The Coal
Authority

Re: Planning application 2023/62/91116/E

Erection of 77 dwellings, with access from Darley Road and associated works at Land off Primrose Lane, Hightown, Liversedge – FURTHER RECONSULTATION

The Coal Authority response: MATERIAL CONSIDERATION

PRIMROSE LANE
 PROPOSED SITE LAYOUT

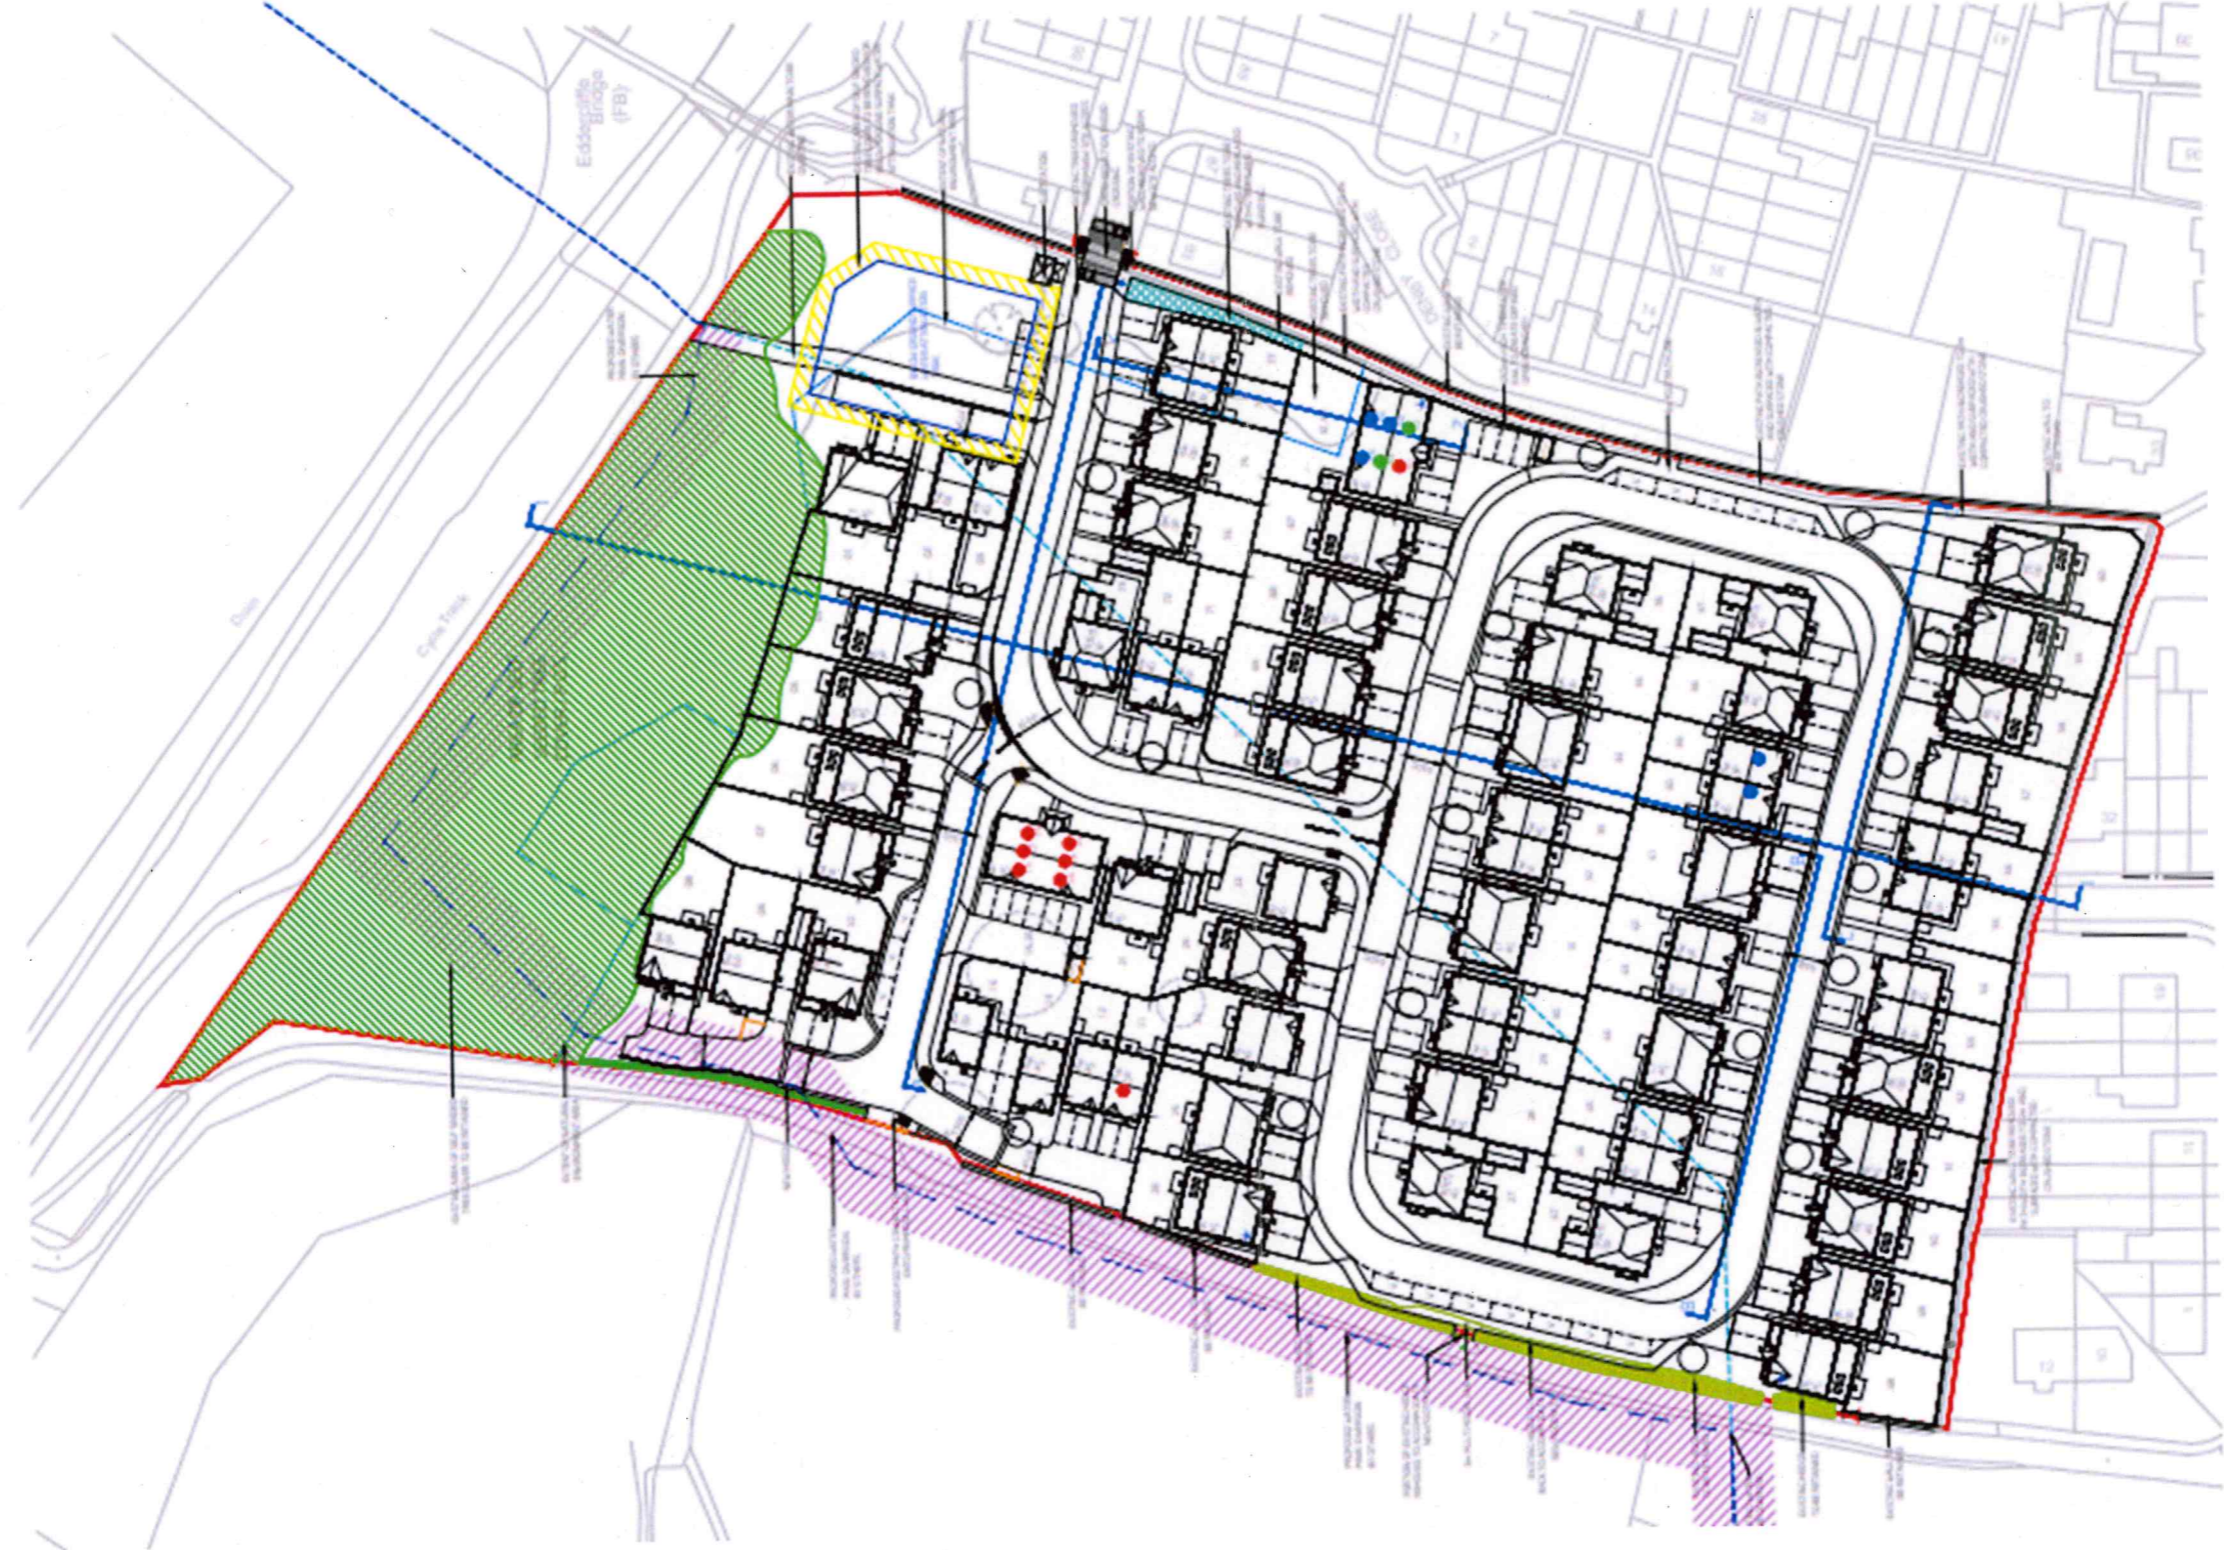
The report highlights that mine shaft 419424-014 has previously been located within the southern part of the site. You will recall from our last response letter that information previously submitted confirmed that this feature is to be appropriately treated. Built development at the affected plots (nos.54 and 55) has also been rearranged to accommodate the associated residual risk posed by this feature.

As we pointed out previously, we wish to highlight that the current extent of fencing around shafts 419424-004, 419424-005 and 419424-006, does not encompass the entirety of their associated potential ZOIs as defined on the Mine Shaft Zone of Influence Drawing. As such, in the interests of public safety we consider that suitably robust fencing of an appropriate design and height should be erected in order to prevent public access across the ZOIs of these shafts.
